FORMAL STRATEGIC OBJECTION: STATE SIGNIFICANT DEVELOPMENT

Development Project: 138 Maroubra Road Mixed-Use Proposal (SSD-81426710)

Objecting Party: Surrounding Locality Residents & Adjoining Neighbours

- PROFILE OF SHADOW CAST BY EXISTING BUILDING
- PROFILE OF ADDITIONAL SHADOW CAST BY PROPOSED DEVELOPMENT
- PROFILE OF SHADOW CAST BY SURROUNDING BUILDINGS

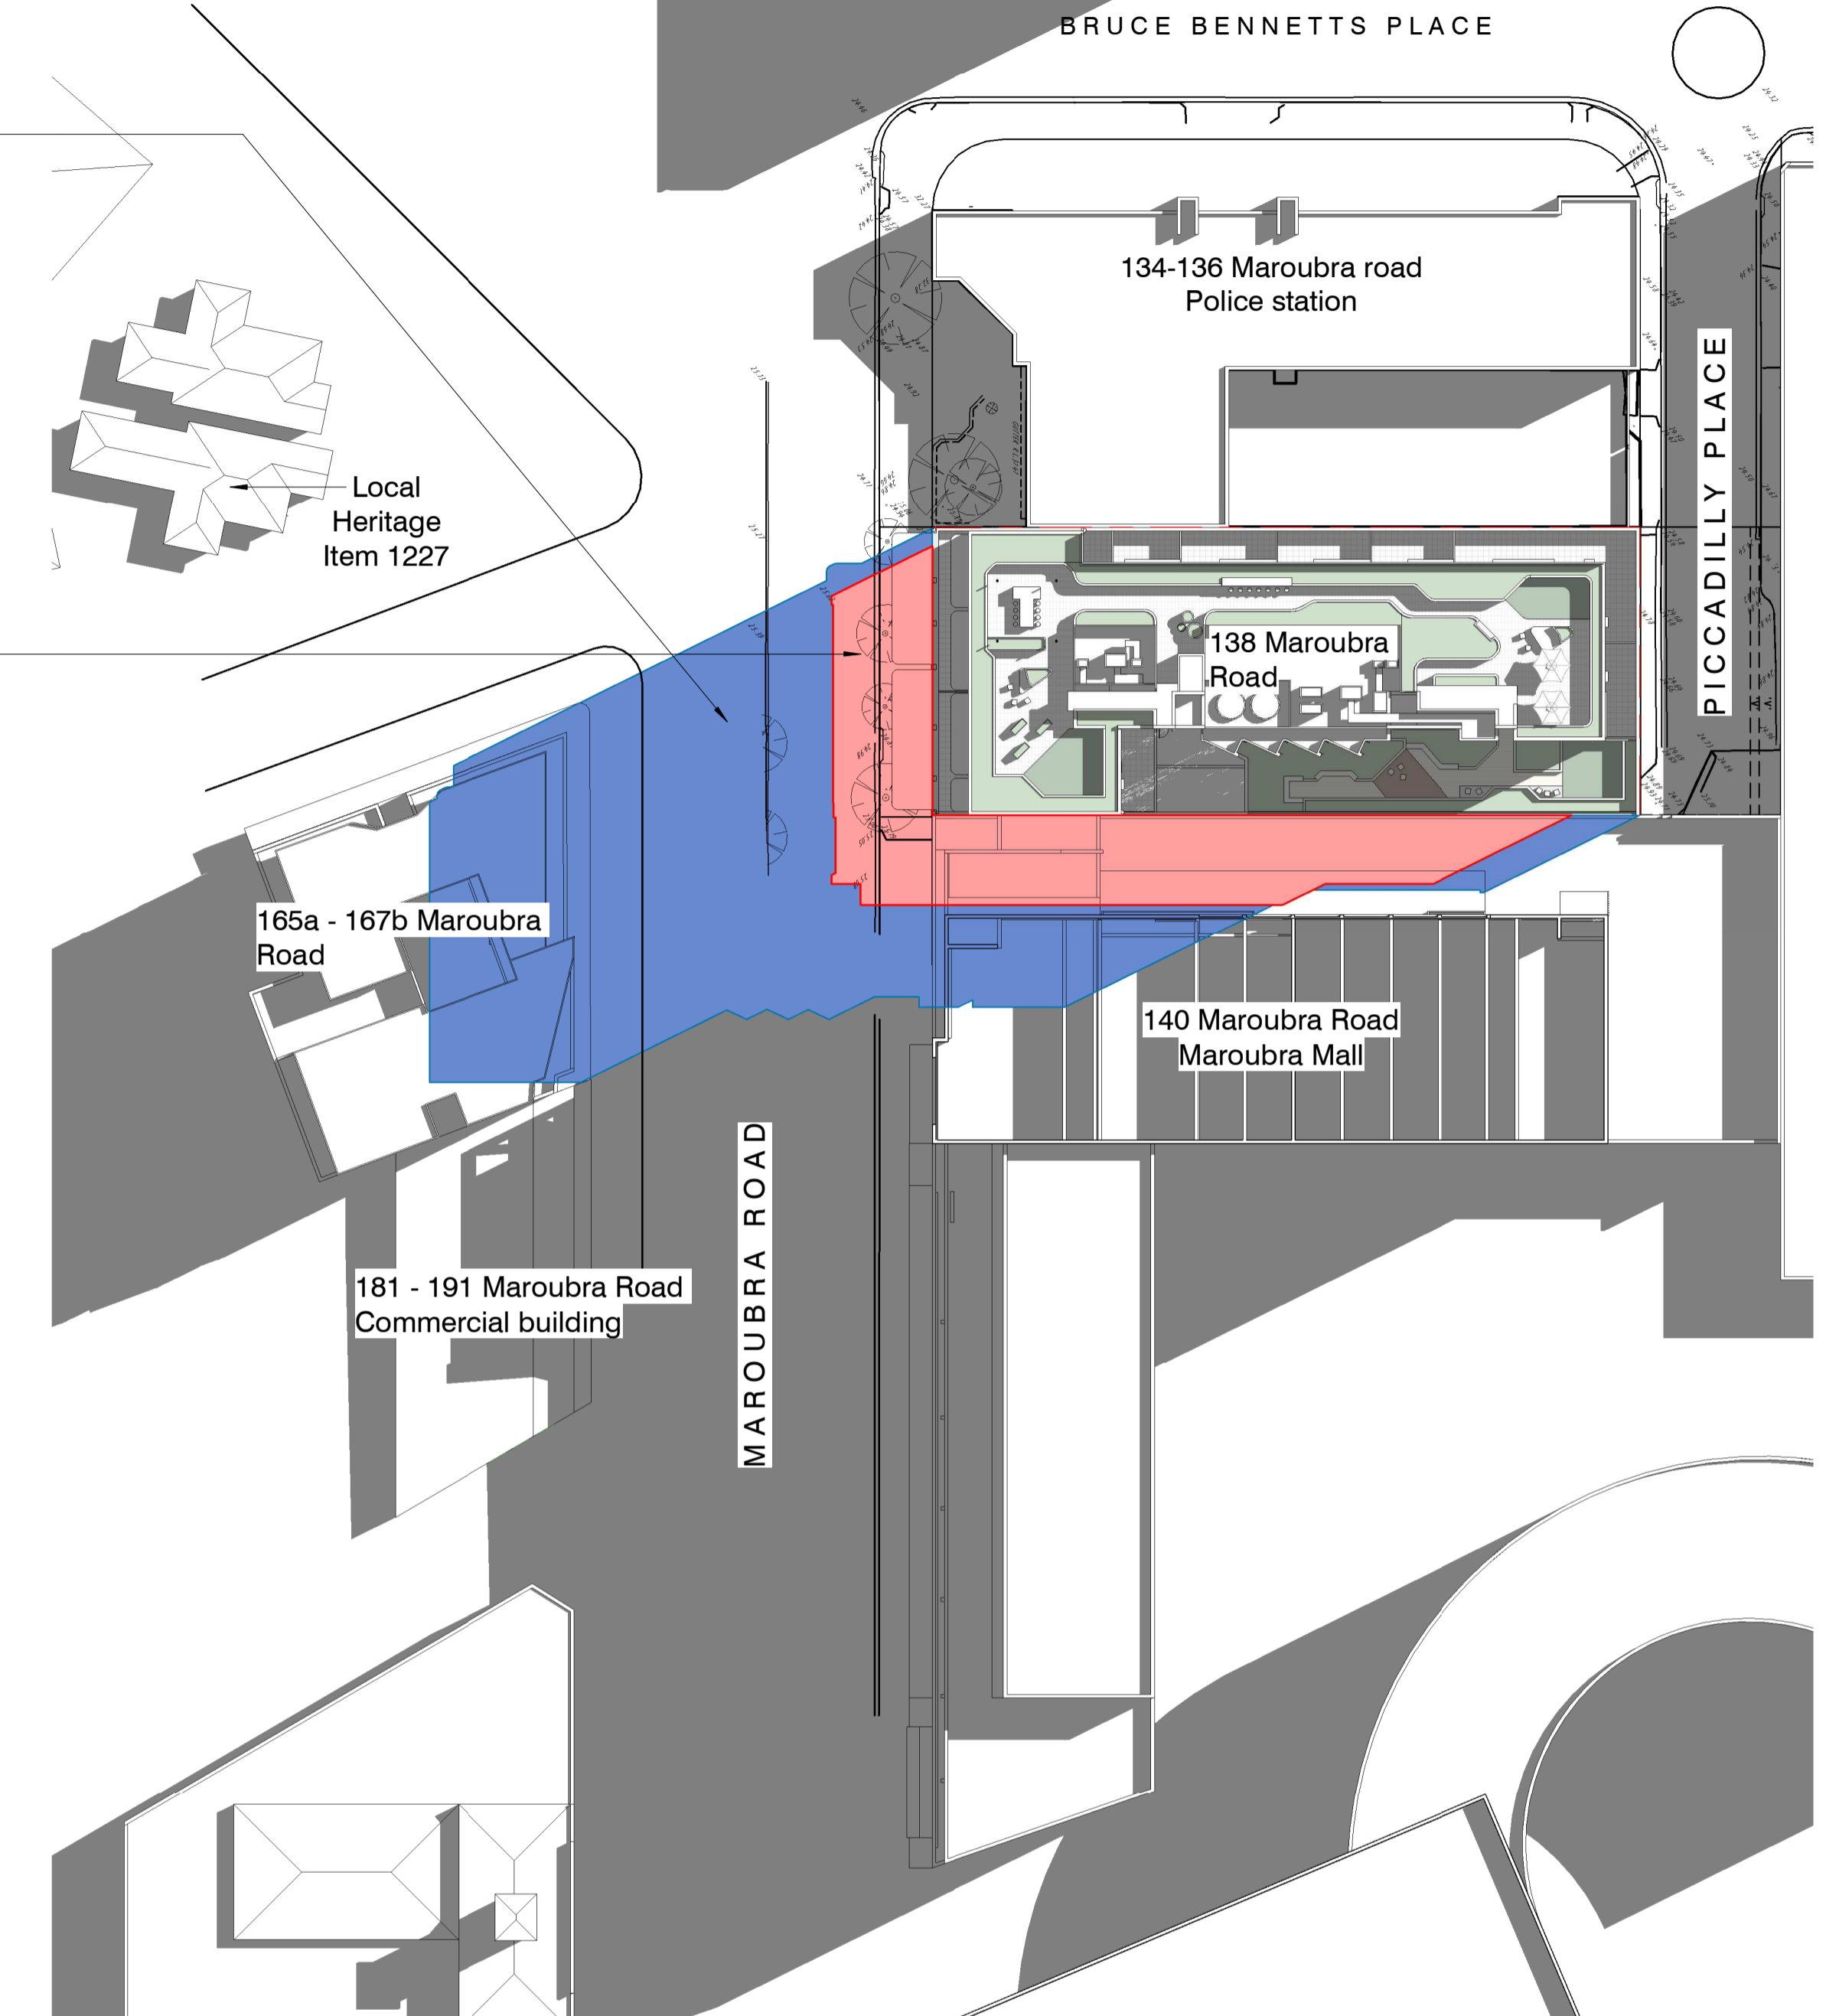
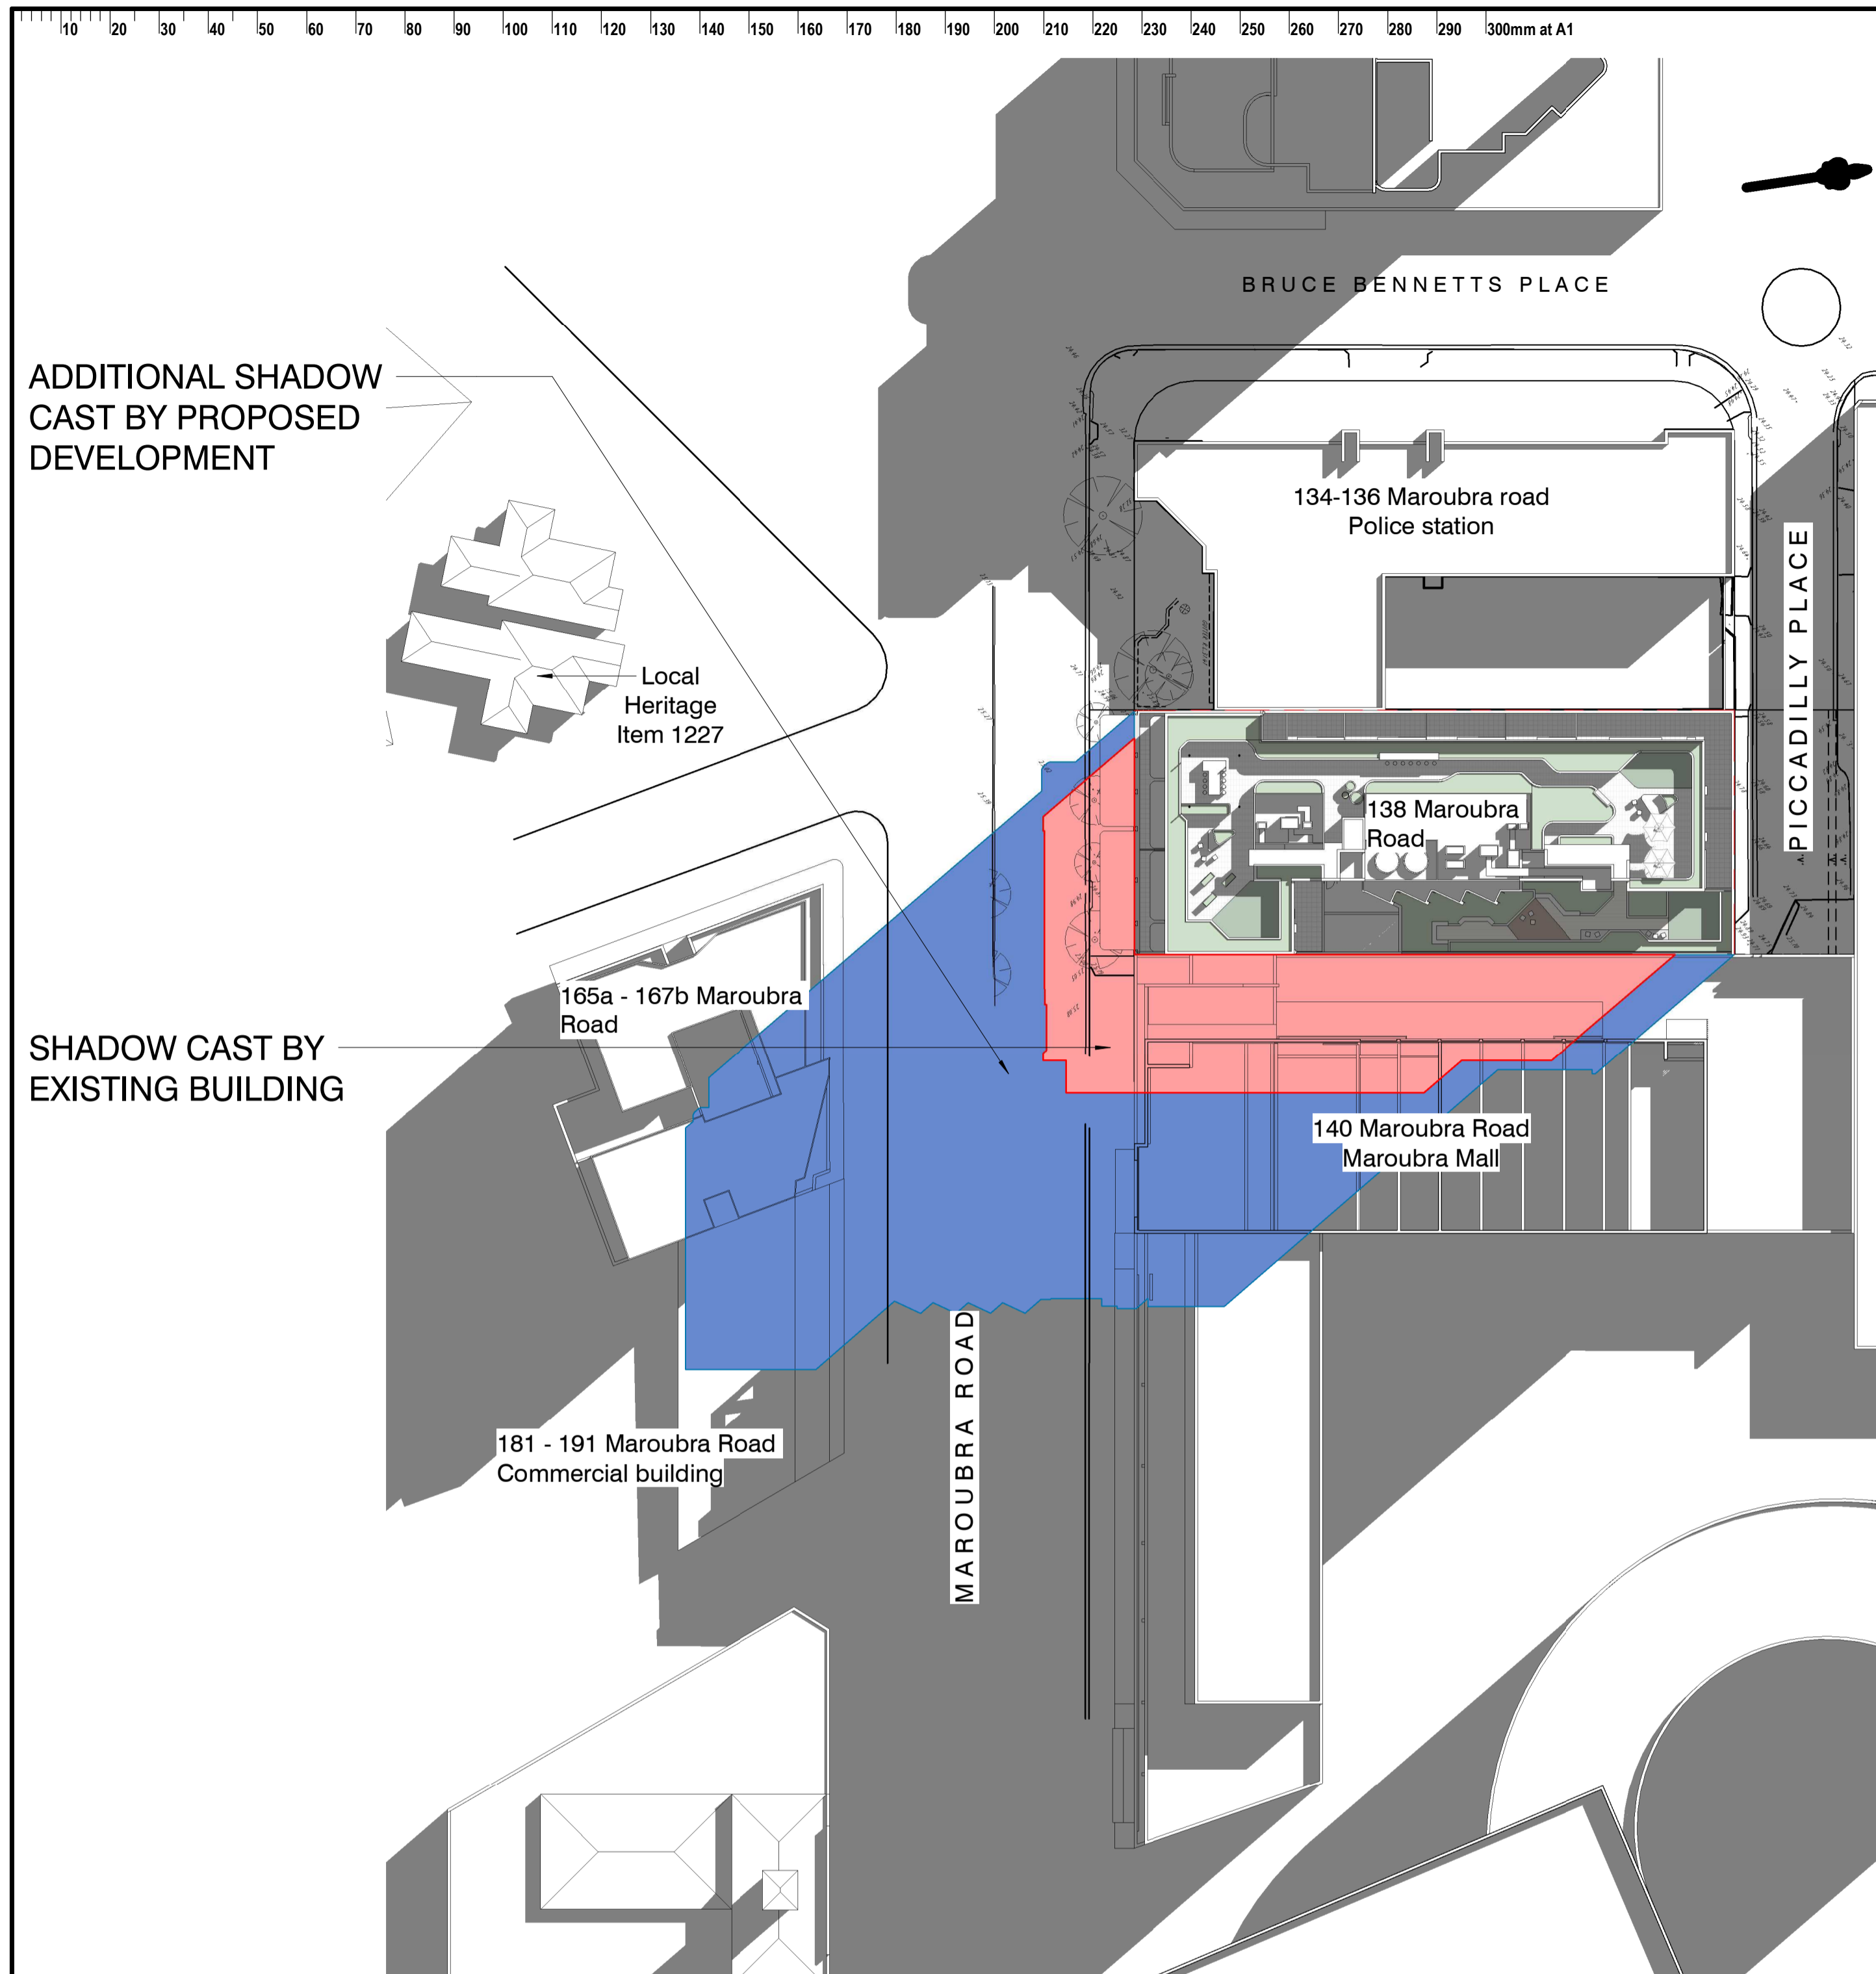
The applicant's submitted shadow modeling relies on broad, regional averages under the Apartment Design Guide (ADG), completely overlooking the localized microclimatic reality of adjoining homes. Building a deep, vertical 10-storey structure directly to the west completely cuts off essential afternoon daylight.

Natural sunlight is a basic requirement for health, physical comfort, and natural apartment temperature control. Stripping adjacent homes of afternoon light hours degrades the baseline well-being of the surrounding community. This loss is felt most acutely by our less-mobile senior residents who stay indoors and rely heavily on natural sunlight for physical health and daily internal warmth.
